From: Peter Jermany <Peter.Jermany@West-Norfolk.gov.uk>
Sent: 10 August 2021 15:29
To: Kelly Sensus <kelly@sensusarchitecture.co.uk>
Cc: Ruth Redding <ruth.redding@west-norfolk.gov.uk>
Subject: Re: Invalid Letter 21/01543/F

GROUND FLOOR PLAN

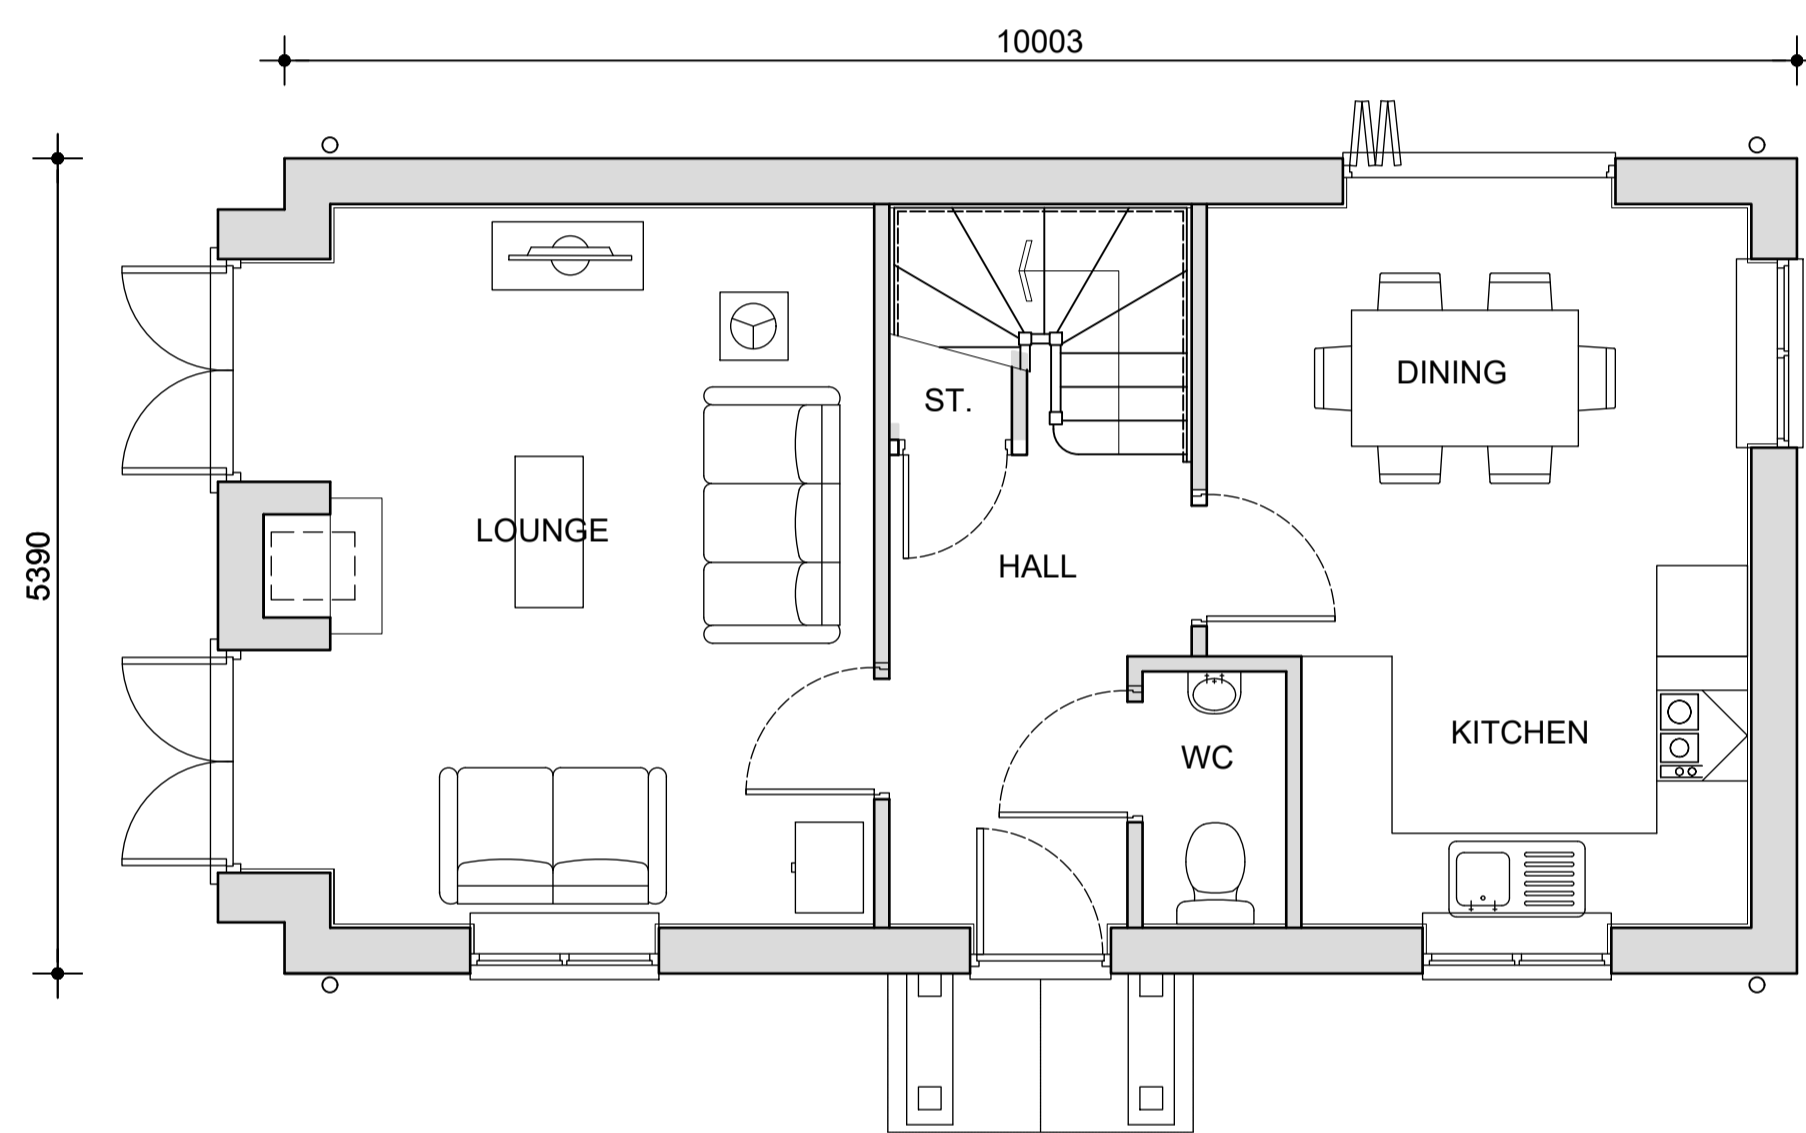
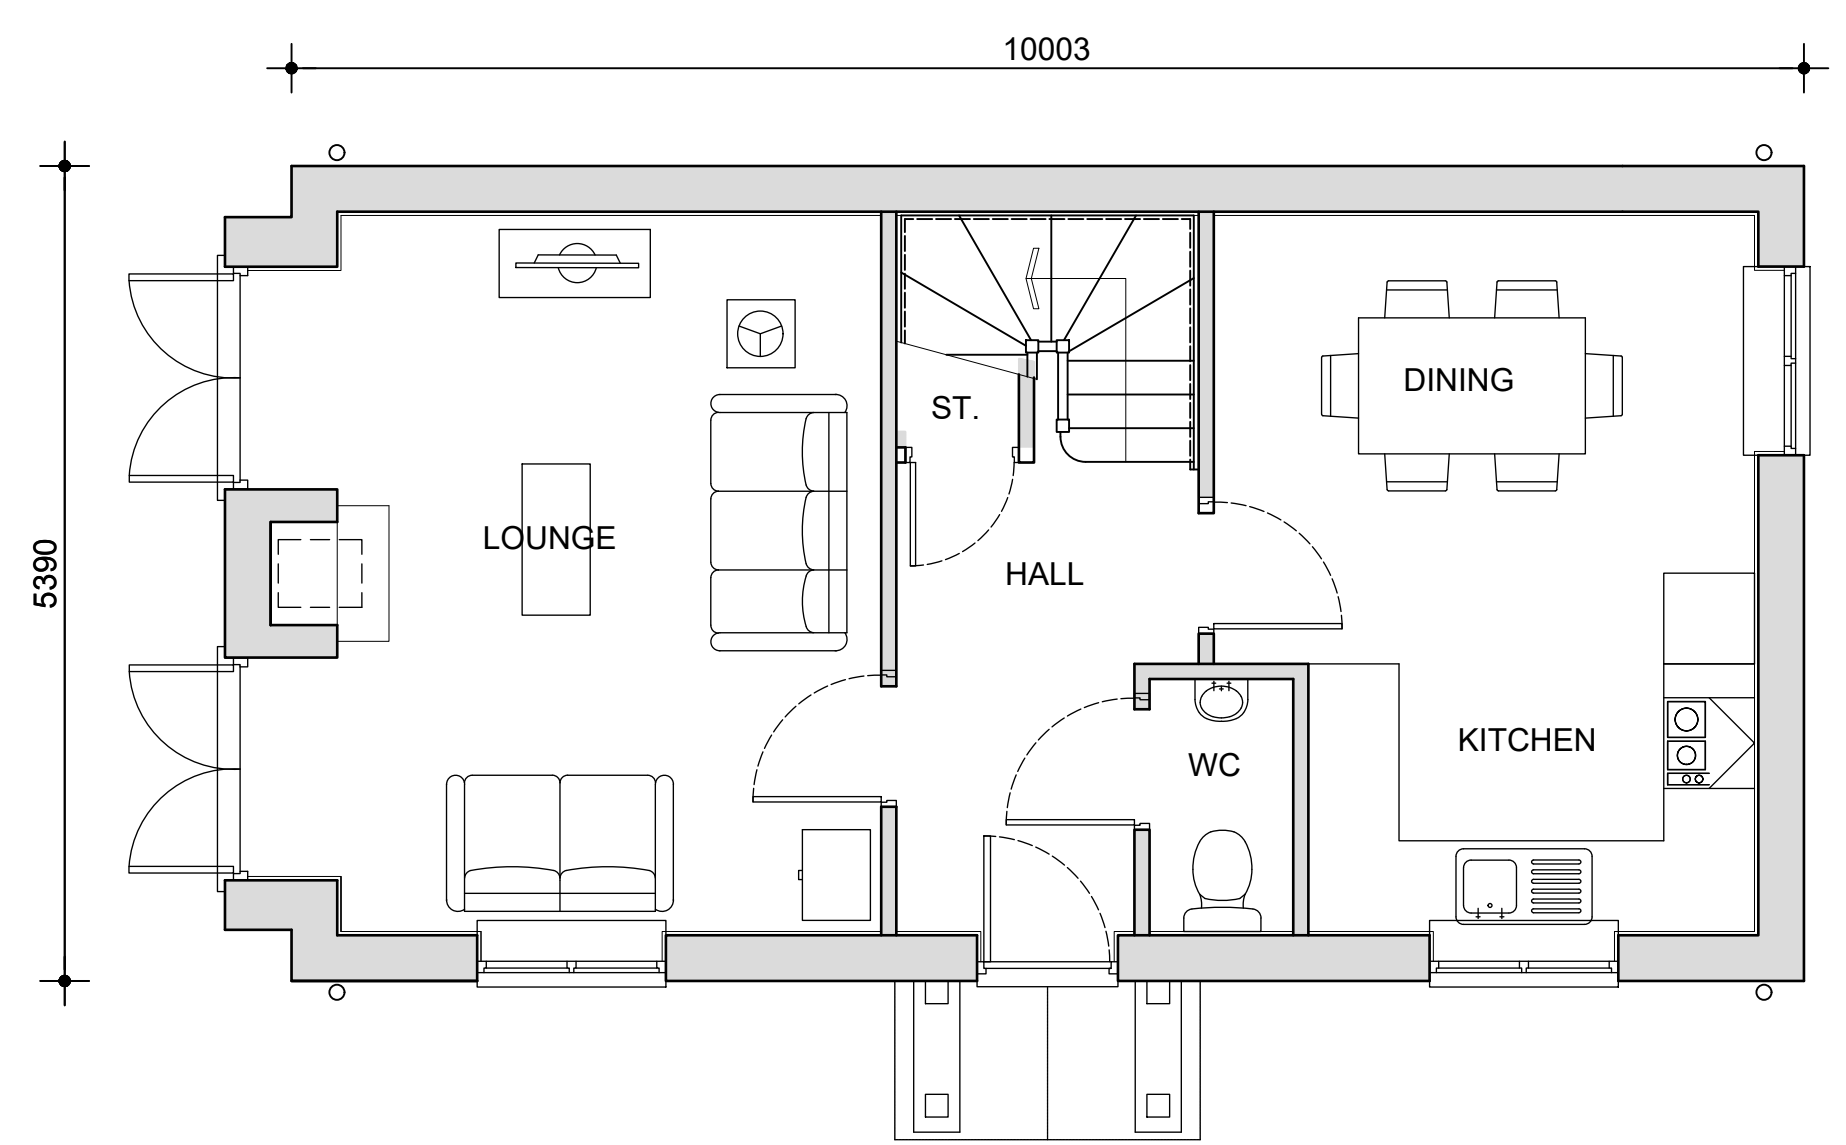
1. Contaminated Land Questionnaire (unfortunately, this wasn't attached to your email as stated?)
2. Habitat Fee (refundable on request, should the application be refused)
3. Flood Risk Matrix (editable version attached).
4. Section-through new dwelling
5. Item 7. On my colleagues email (slight error on the proposed ground floor plan)

SECTION

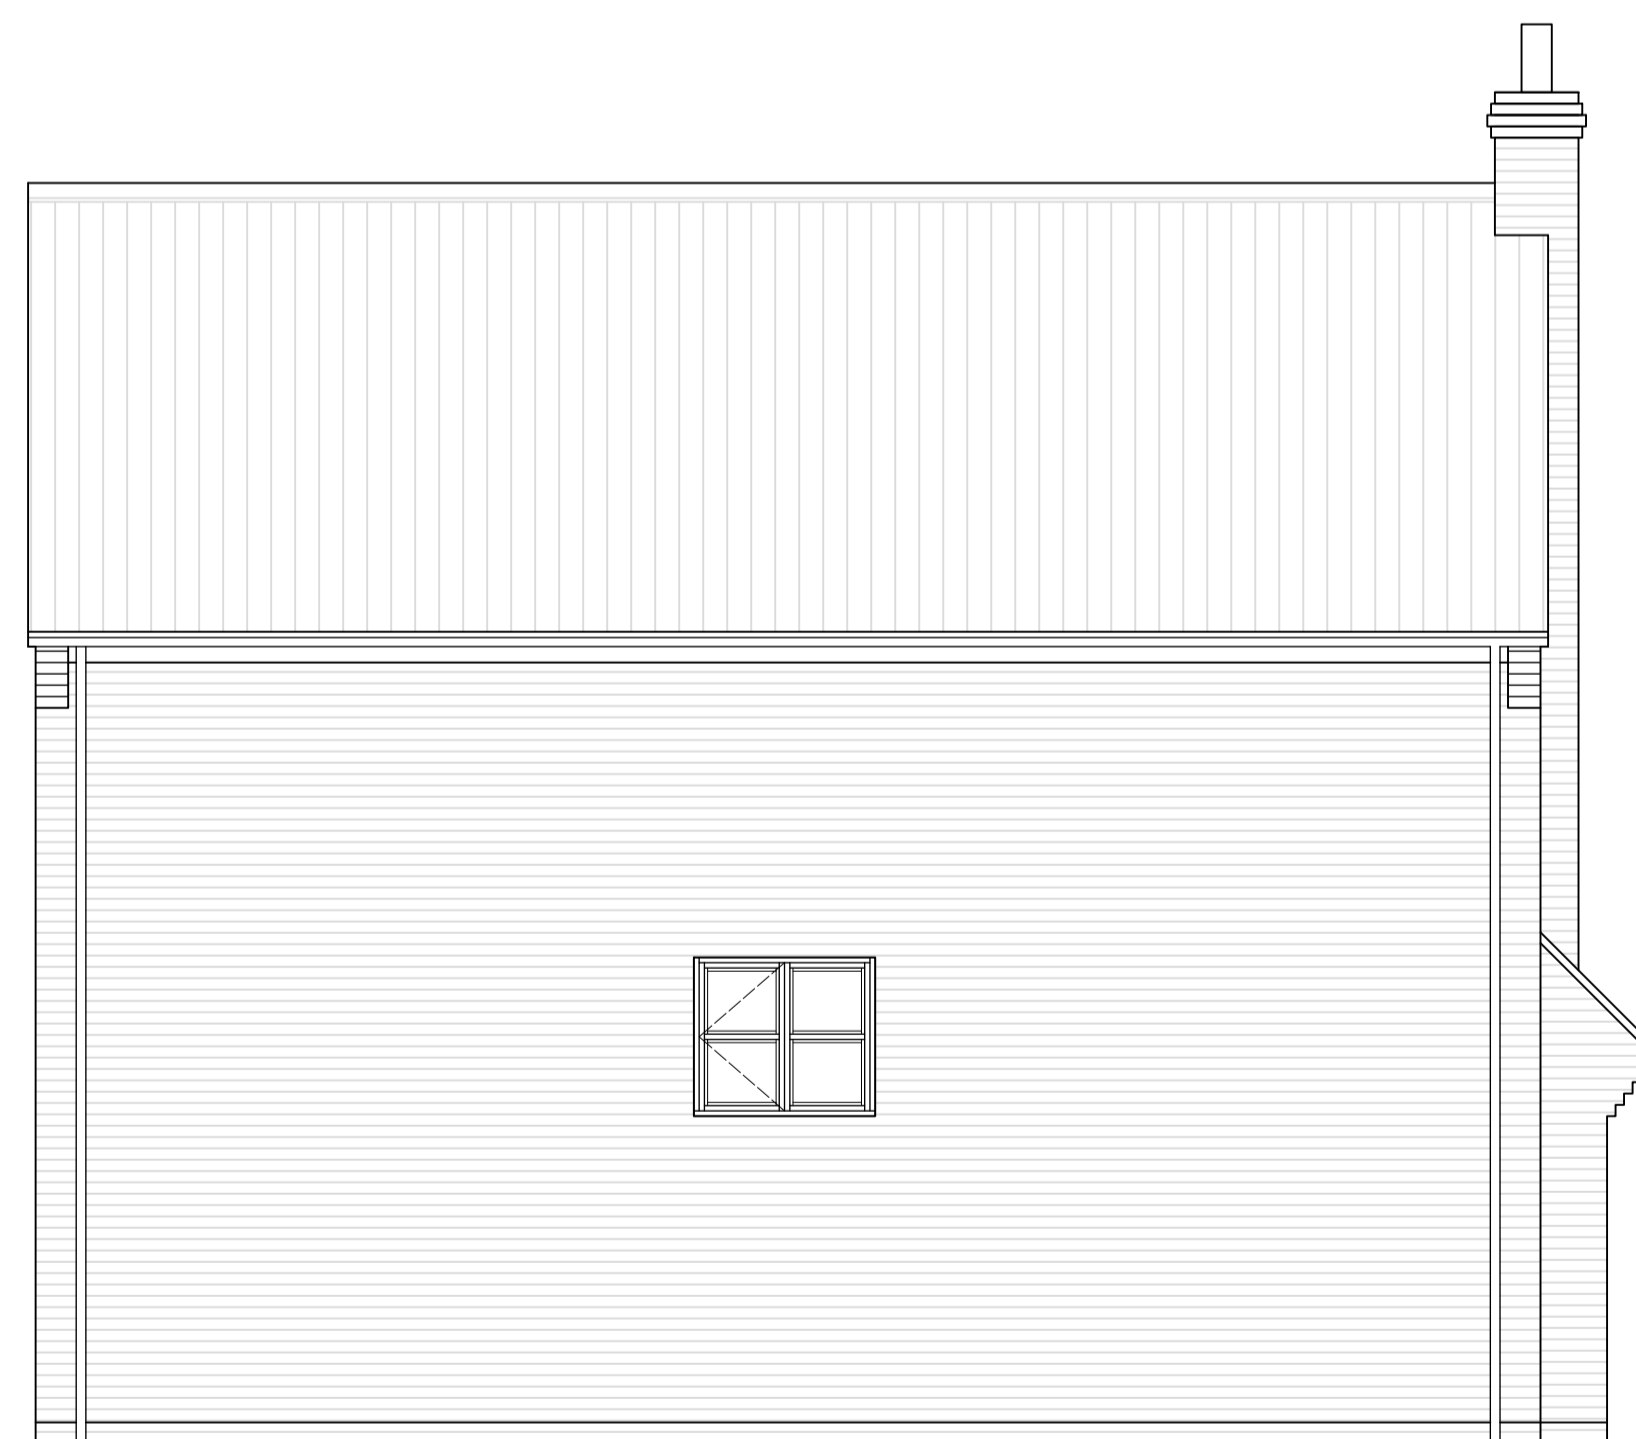
1. CIL Form – received thank you.
2. I have attached a simplified Contamination Form. Please can you complete this to the best of your knowledge and return it.
3. As this is a new application I will require payment of £55 for the Habitat Mitigation Fee. If the application is refused and no appeal received within 6 months, a refund of the £55 Habitat Fee will be refunded on request.
4. The Site lies within an area at Risk of Flooding. The Environment Agency are a Statutory Consultee for flooding, therefore a Full Flood Risk Assessment will be required.
5. In addition to the FRA, please complete the attached simplified Flood Risk Matrix. The site lies within Flood Zones 2 and 3A and is subject to Tidal Breach.
6. I require a section through of the proposed dwelling, in order to ascertain finished floor levels.
7. Please see attached.
